August 8, 2014

**Subject: Congress Street Convenience Store –Portland, Maine
Comment Response # 1
Response to City of Portland Comments of Jean Fraser Dated August 1, 2014**

We have received and reviewed the email review comments dated August 1, 2014 regarding the Amended Site Plan for the 2282 Congress Street Convenience Store project. We have completed plan revisions related to these comments as well as revisions based on the client's value engineering requests. For ease of reference, we have repeated the comments (*italics*) followed by our response.

DeLUCA-HOFFMAN ASSOCIATES, INC.
778 MAIN STREET, SUITE 8
SOUTH PORTLAND, ME 04106
207.775.1121
WWW.DELOCAHOFFMAN.COM
DRAWN: CMW | DATE: MAR. 2013
DESIGNED: SRB | SCALE: 1" = 30'
CHECKED: SRB | JOB NO. 3118
FILE NAME: 3118-SP
SHEET: C-2.0

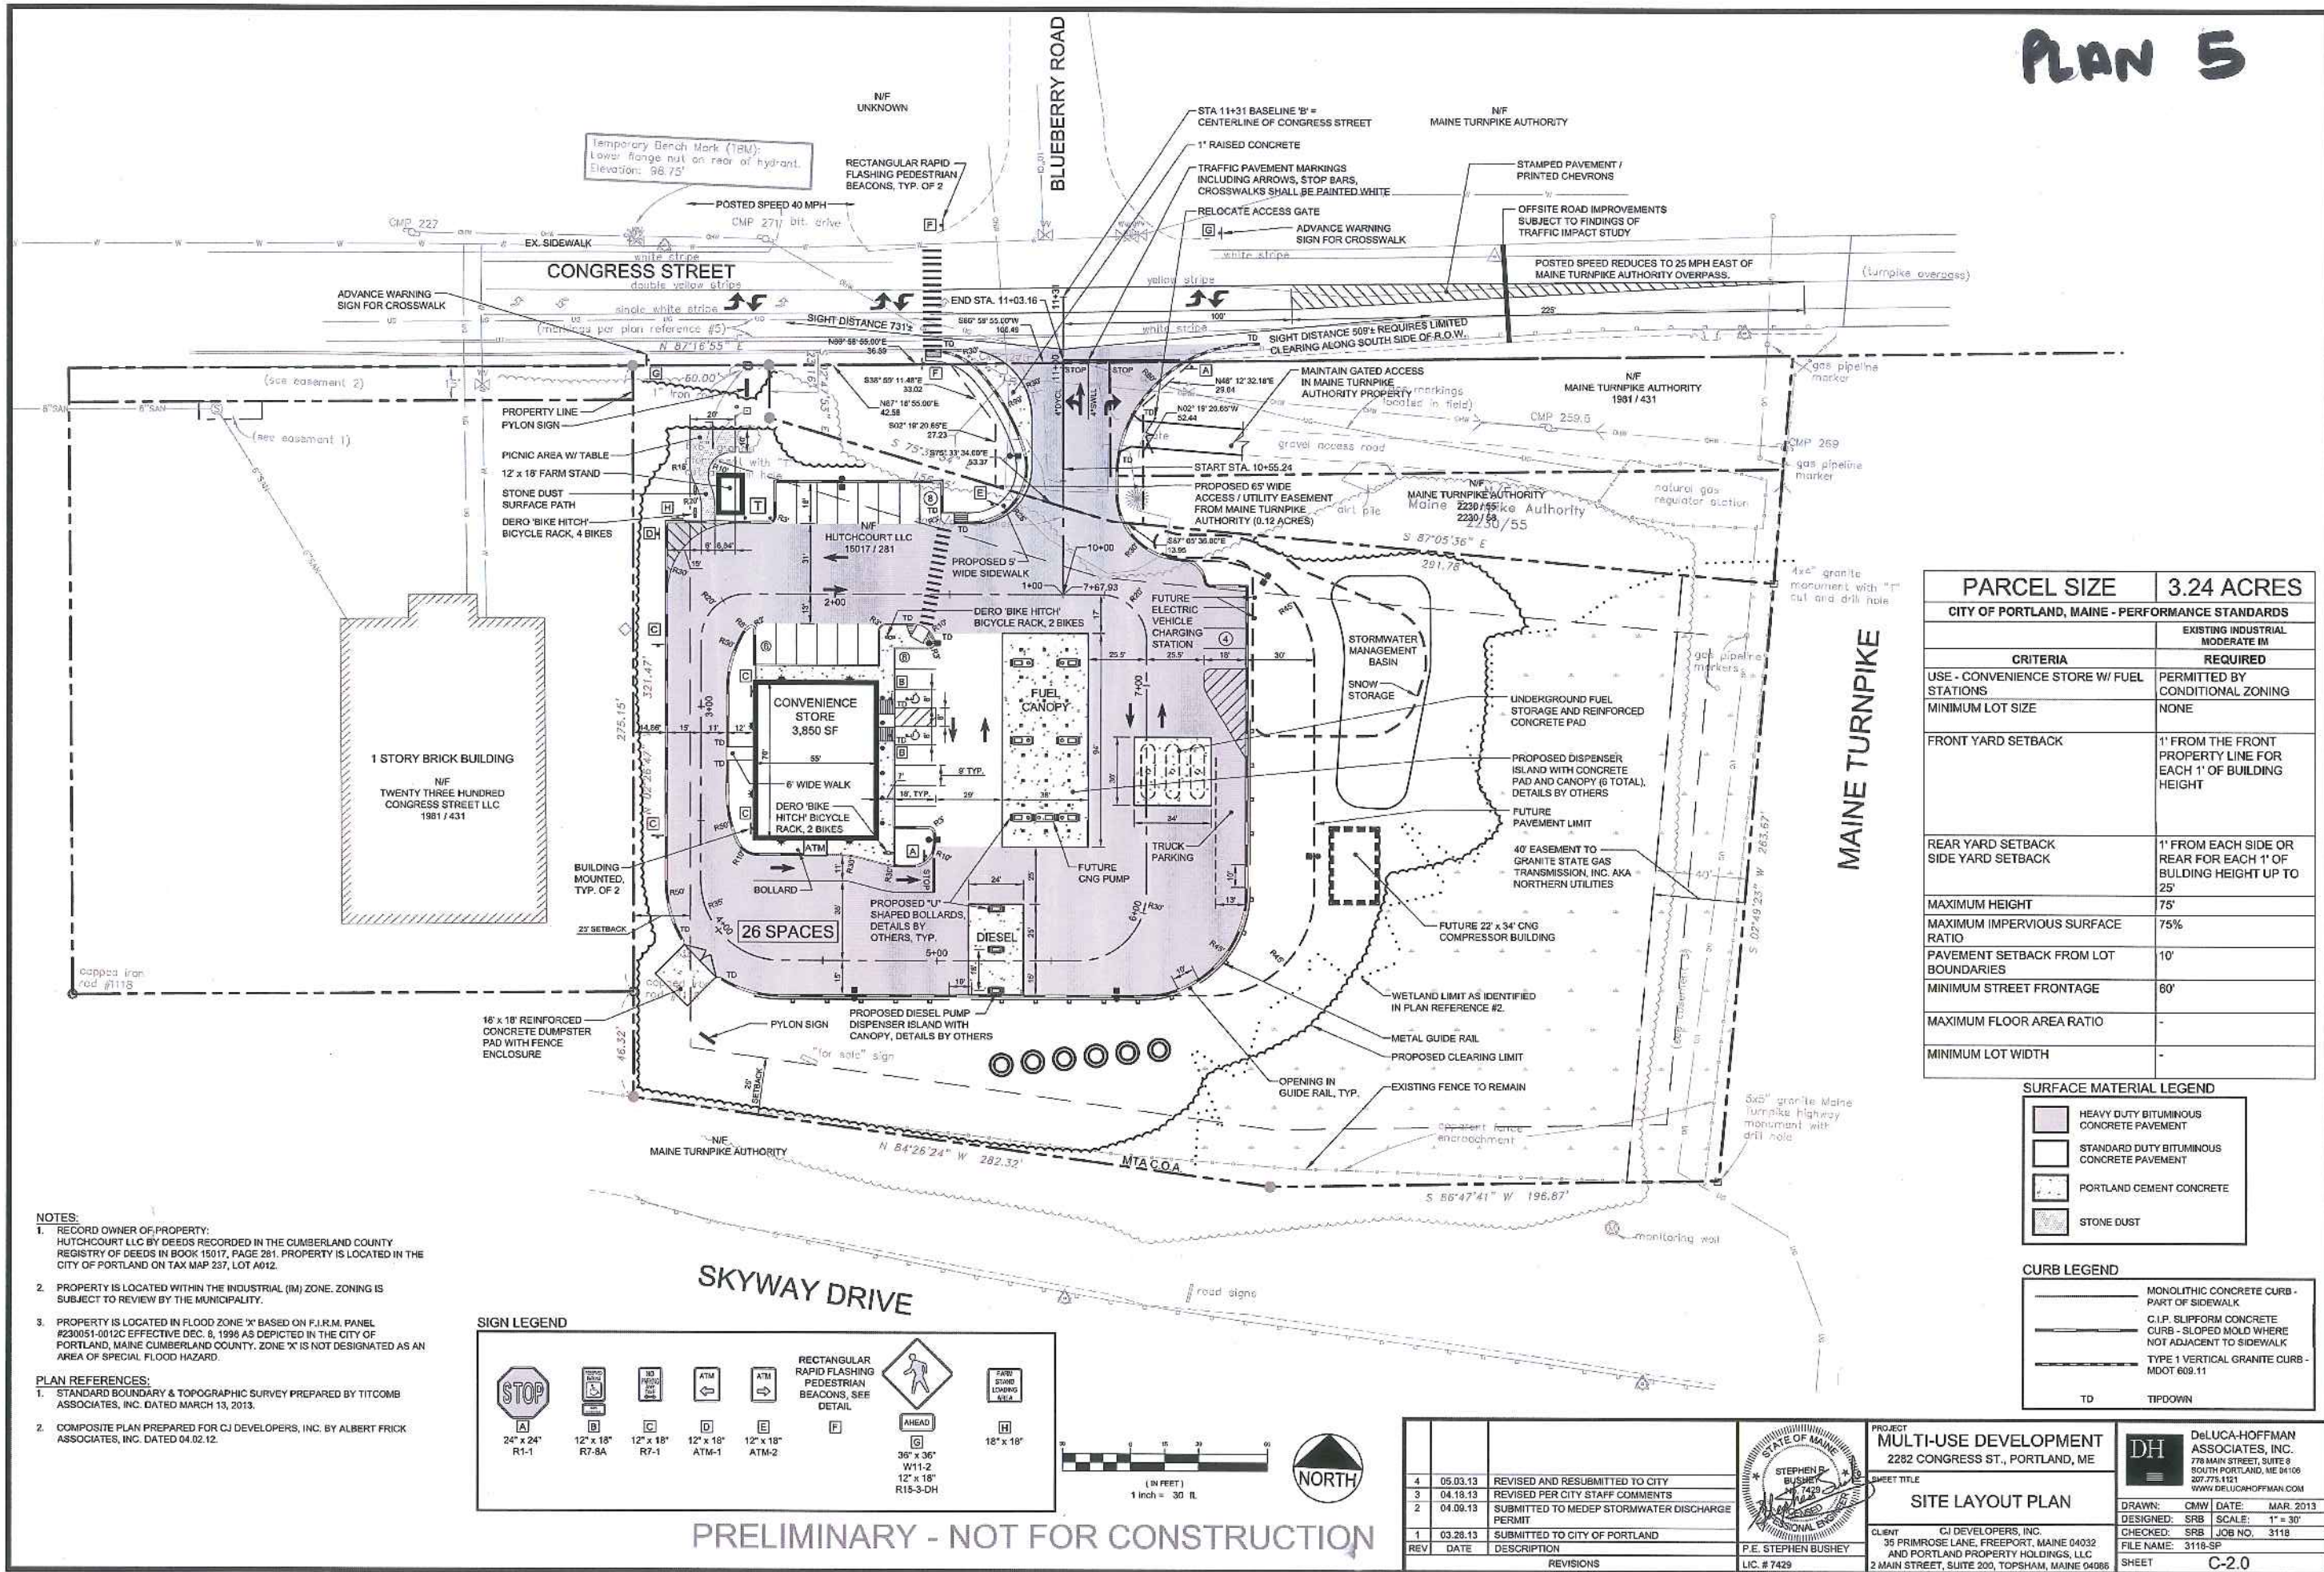
The parking spaces on the Congress St. side need to be set back 10' from the MTA property line.

- The underground storage fuel tanks have been re-arranged to be stacked side by side to reduce the size of the reinforced concrete pad. See Sheet C-2.0.

The accompanying plans have been modified to show the shifted parking spaces meeting the setback requirements from the MTA property line.

SHEET TITLE: AMENDED GRADING AND DRAINAGE PLAN

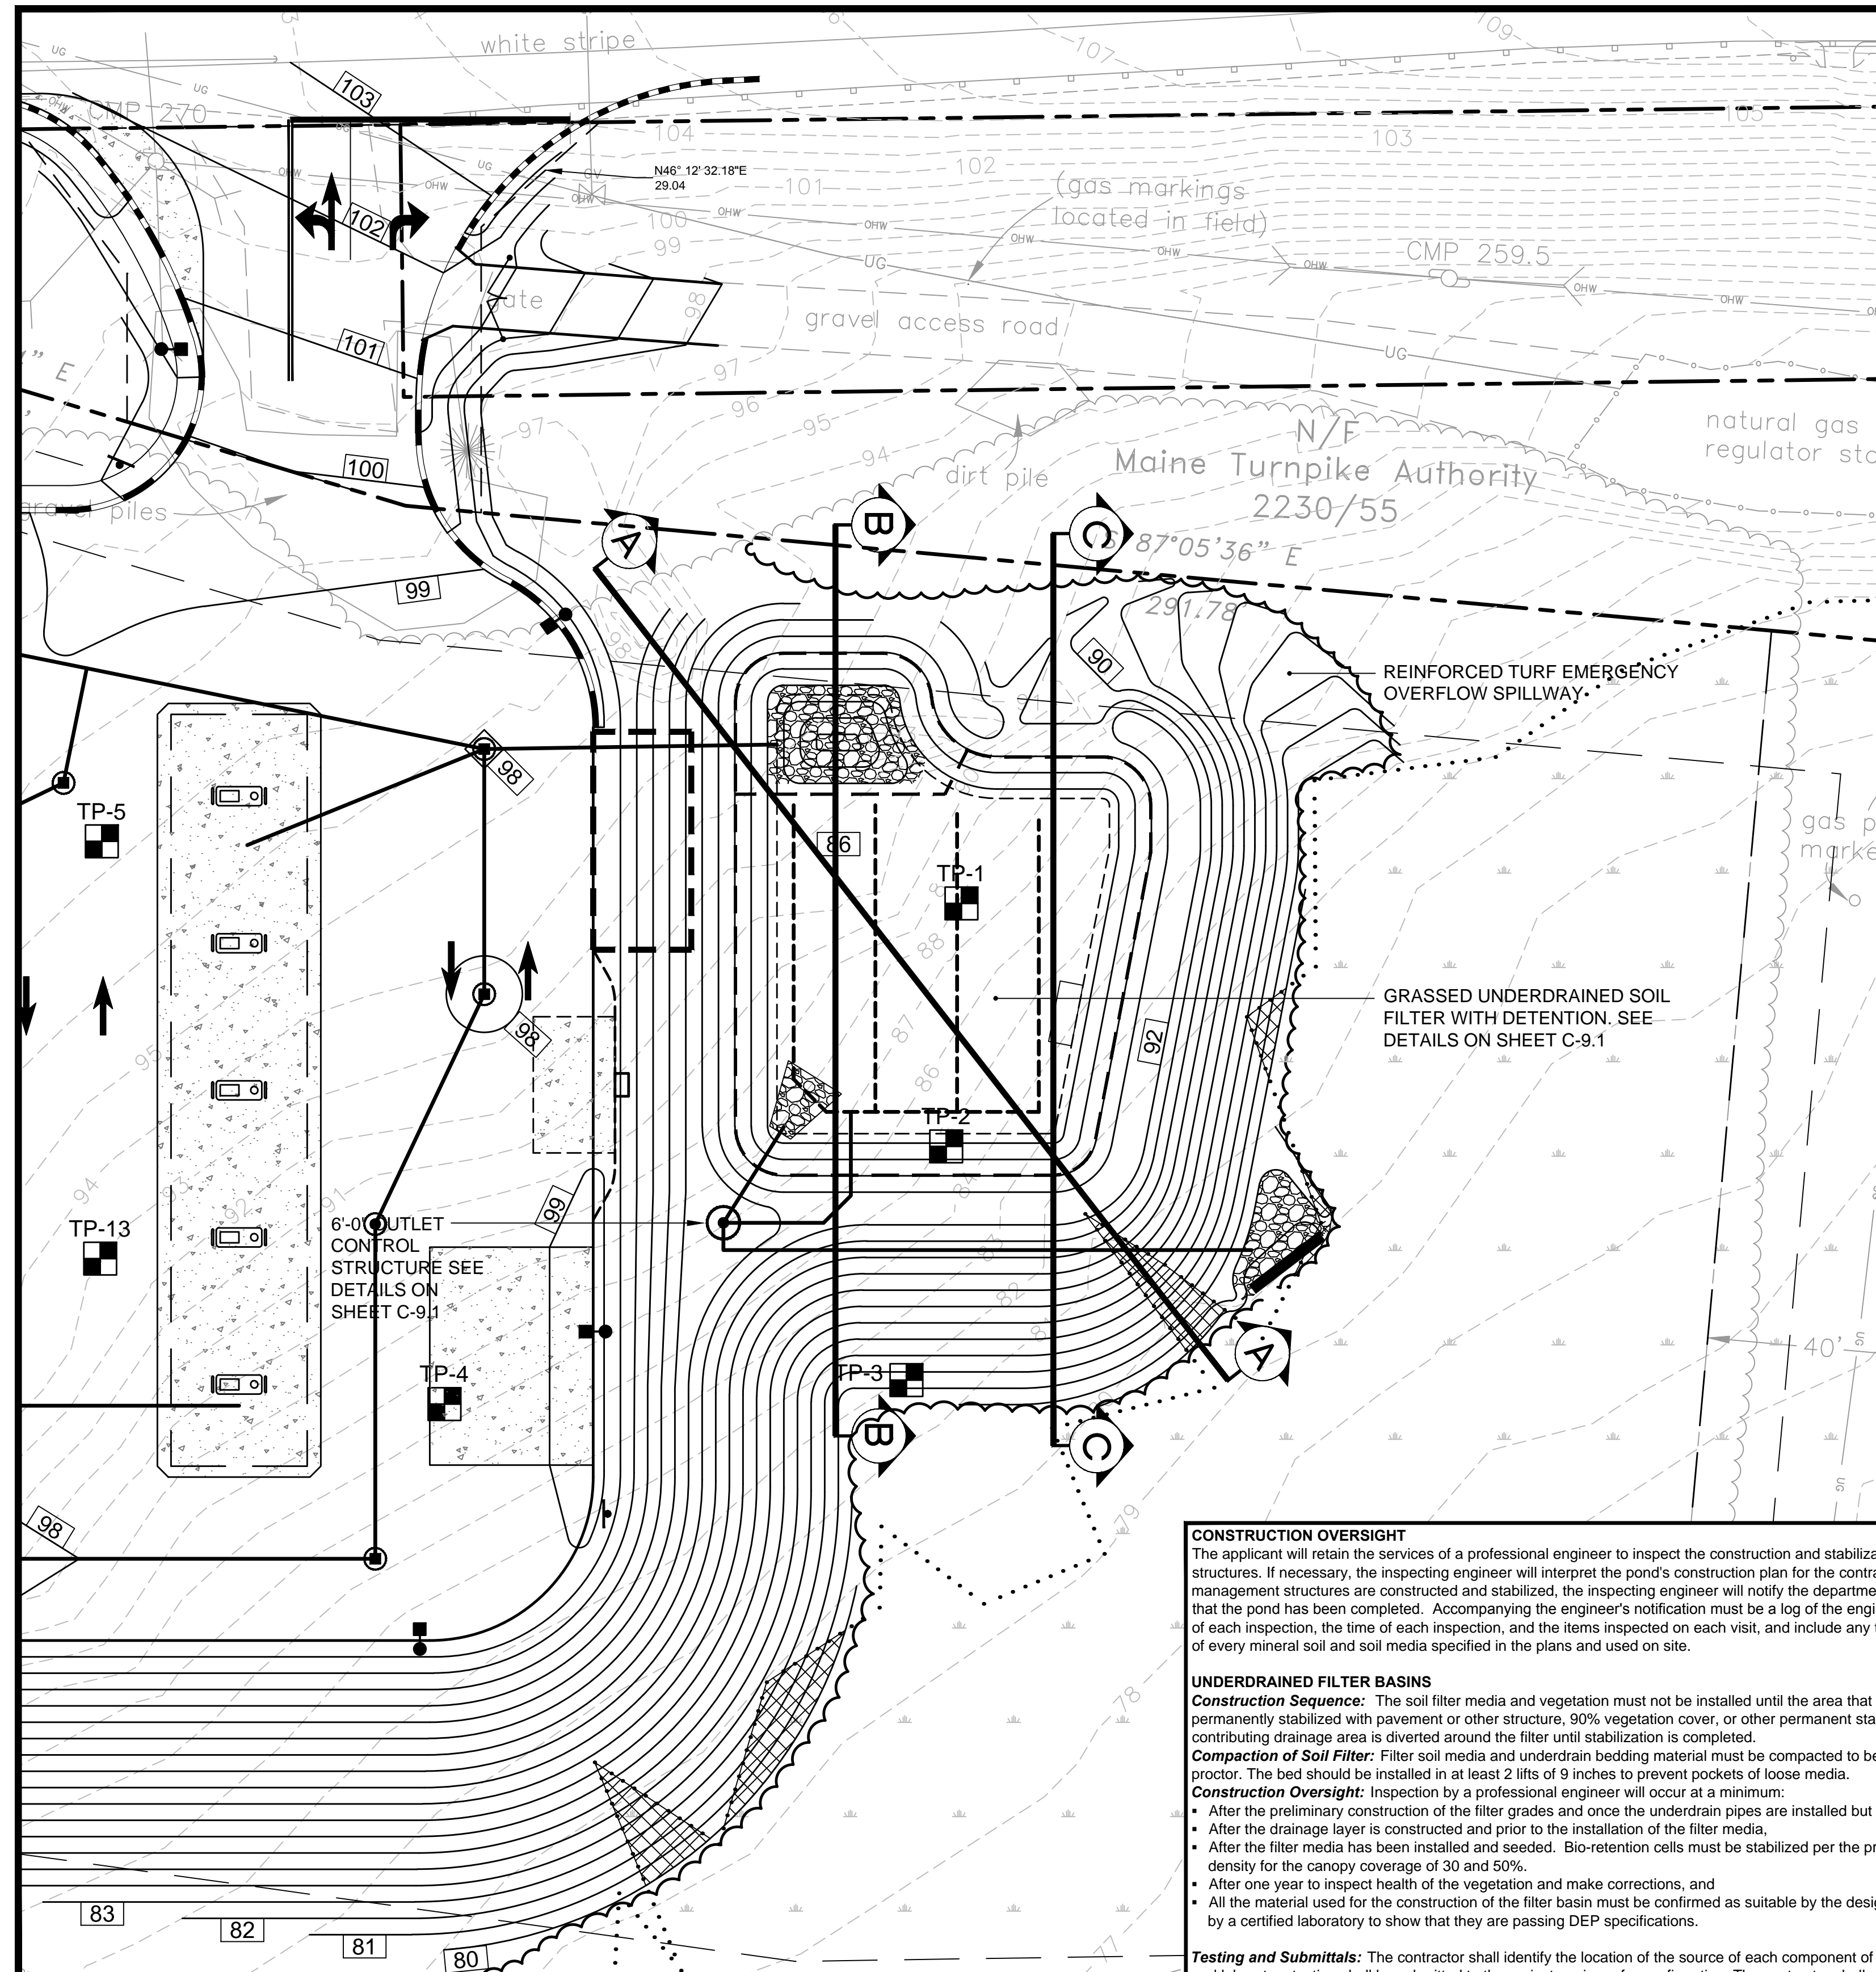
- Curbing has been reduced around the perimeter of site. Grading alterations have been made to Sheet C-3.0 to accommodate these curb reductions.
- The location of the farm stand and picnic areas have been altered to reduce the size of the stone dust path. See Sheet C-2.0.

- Curb has been reduced in the parking stall island behind the ATM machine. Grading alterations have been made to Sheet C-3.0 to accommodate curb reductions.
